DRB Application No.: 08DRB-70420	Project # 1007402
Project Name: PALMS ADDITION	
Agent: JACKS HIGH COUNTRY	Phone No.: 898-3707

DRB Comments

RE: Lot 7, Palms Addition

**PLAT OF
 LOTS 7-A, 7-B AND 7-C
 PALMS ADDITION**

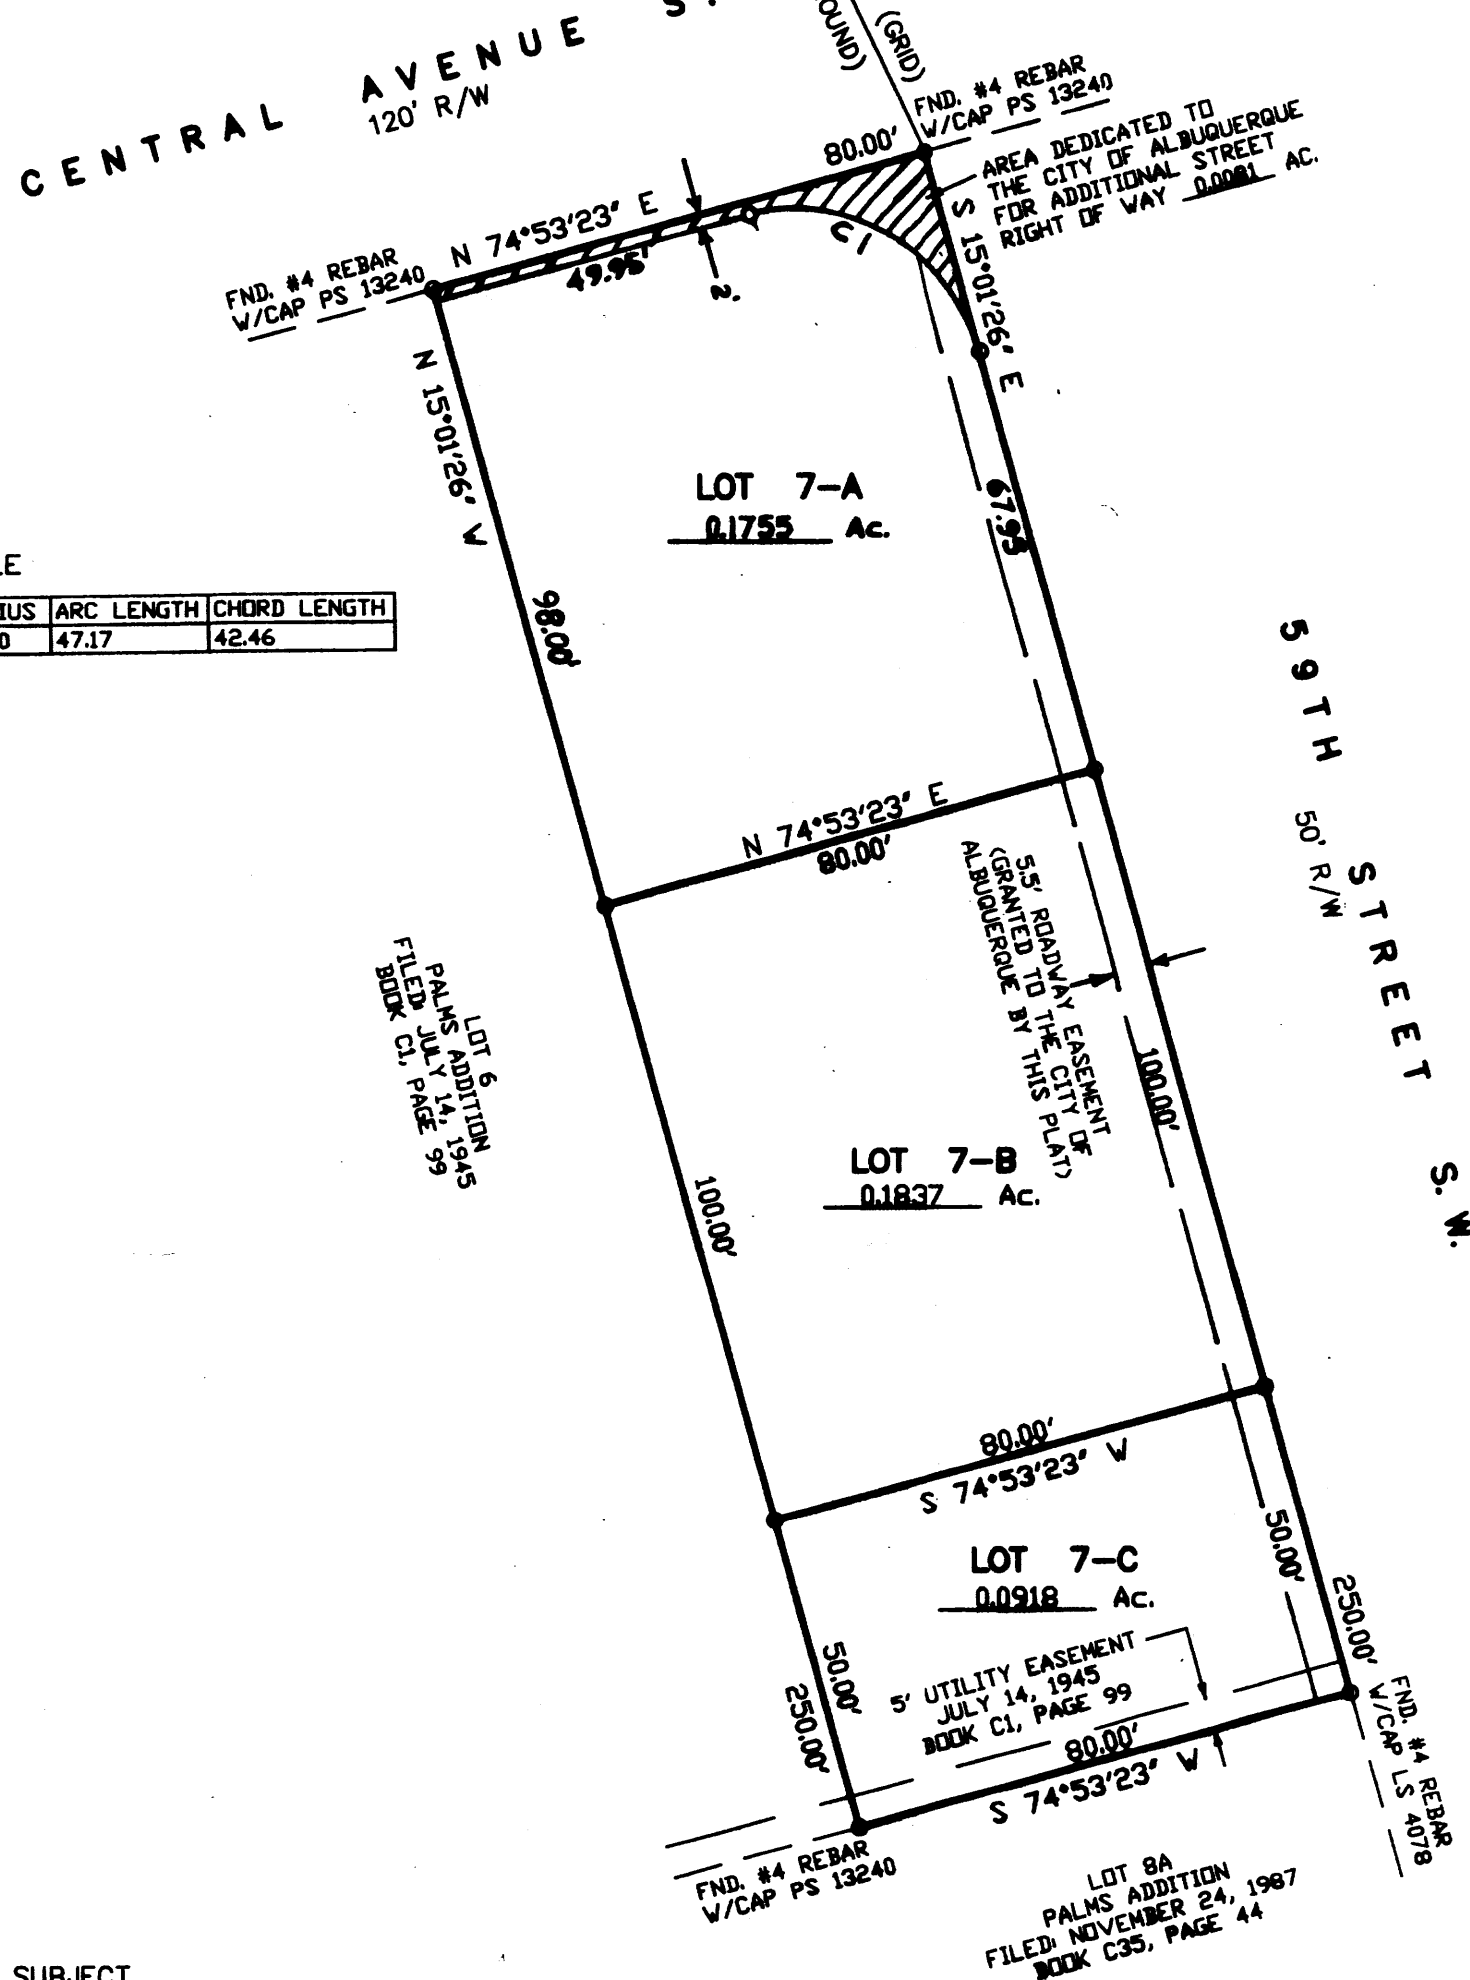
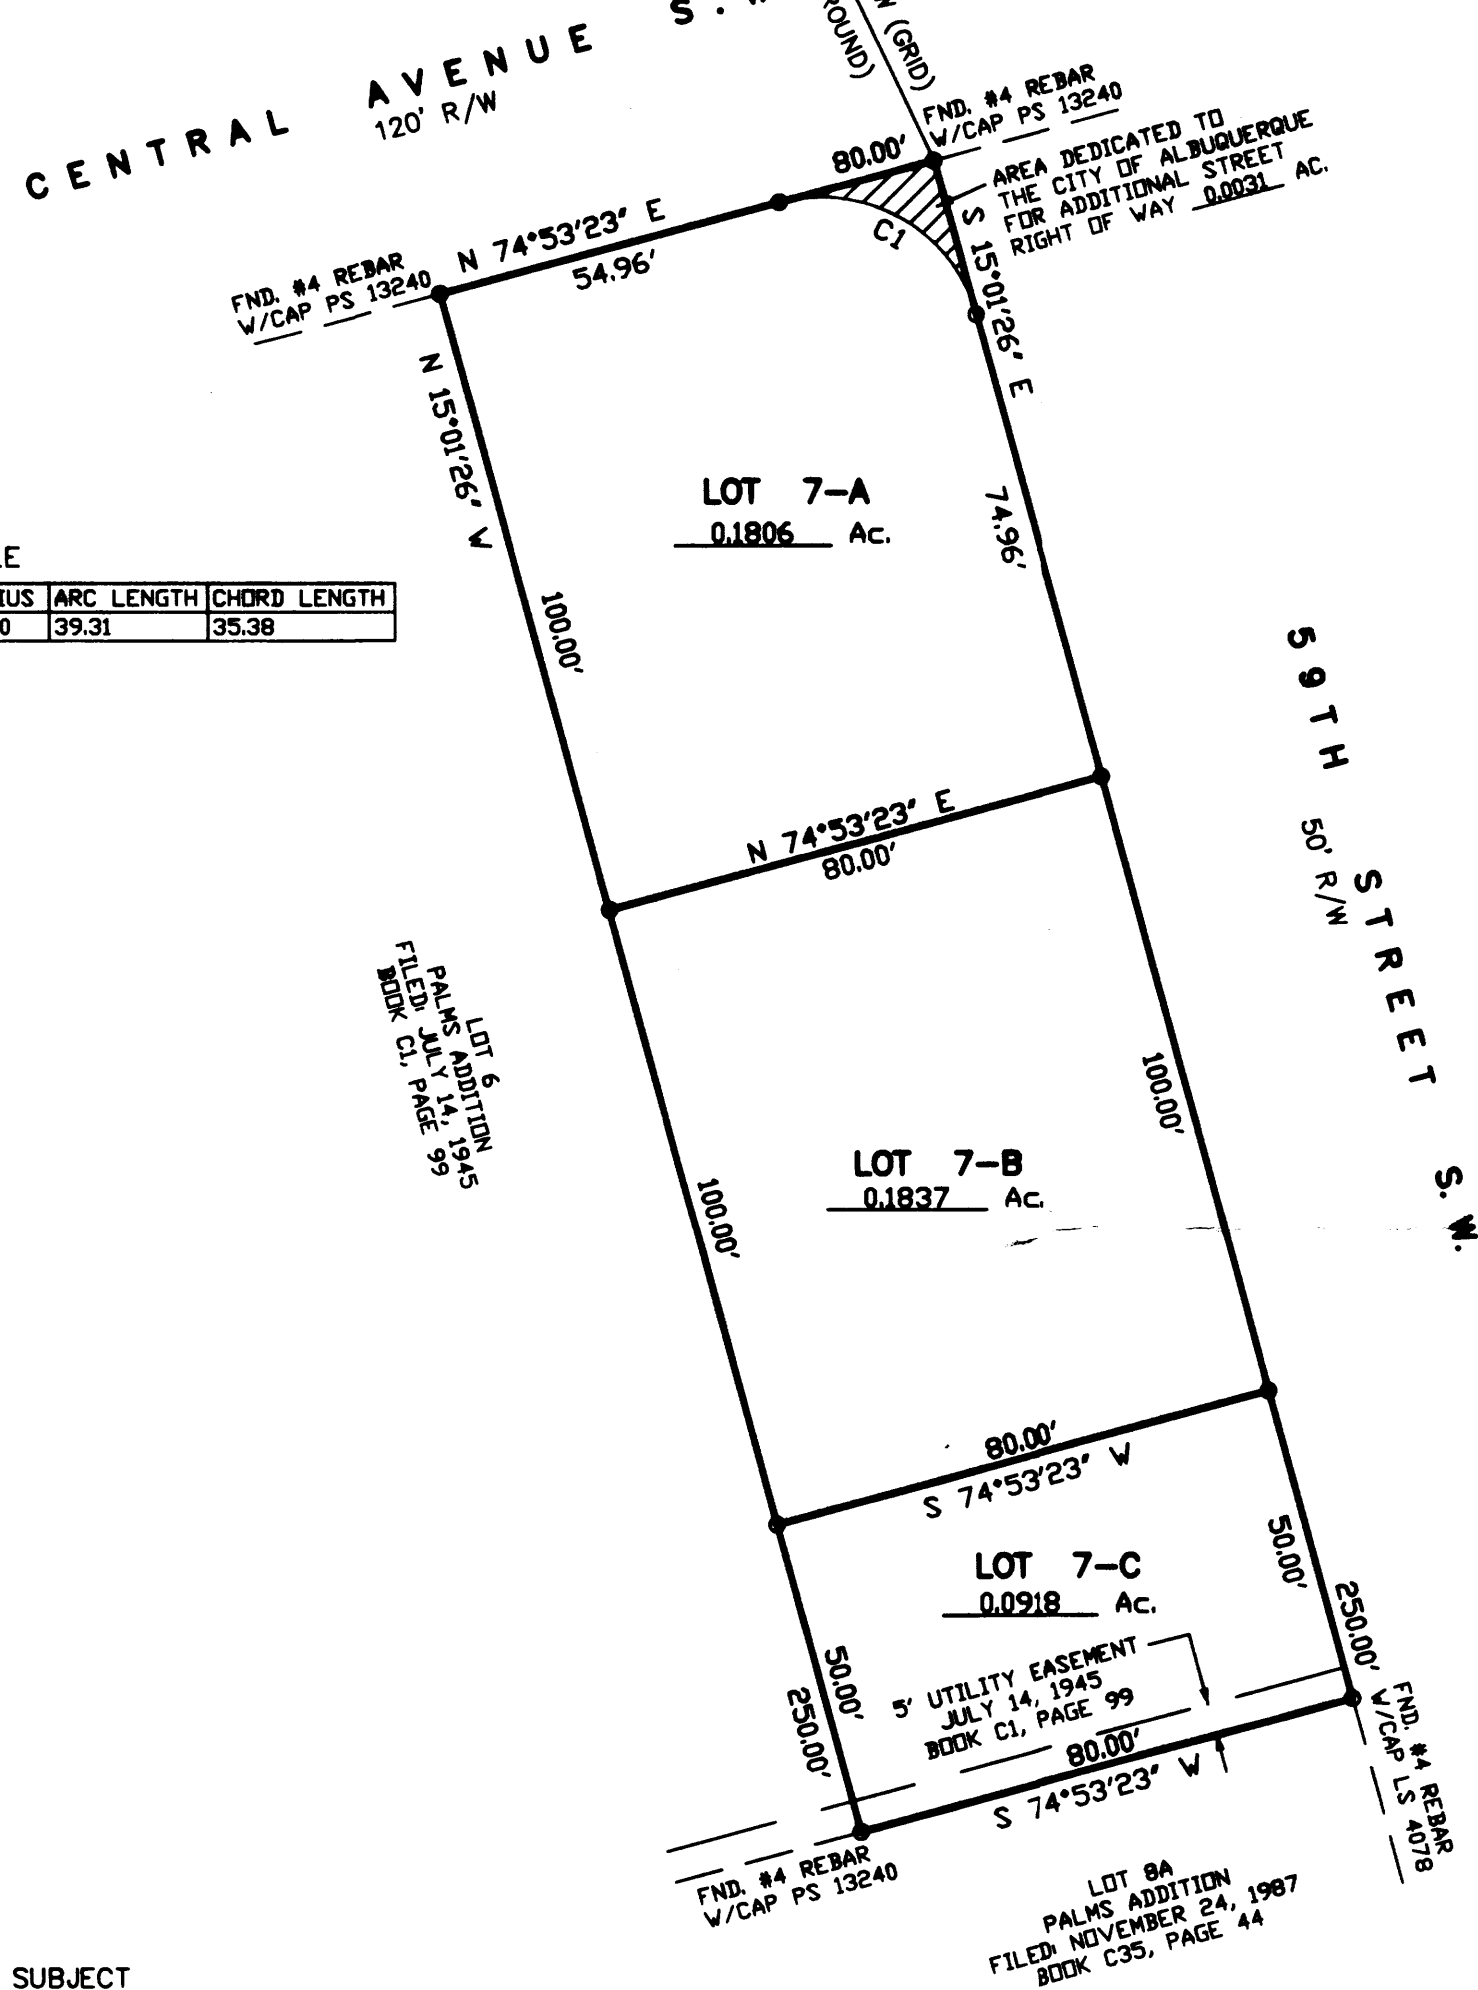
TRANSPORTATION: - verify right-of-way

This site is within the West Route 66 Sector Development Plan; future development will be subject to the Design Overlay requirements of the sector plan.
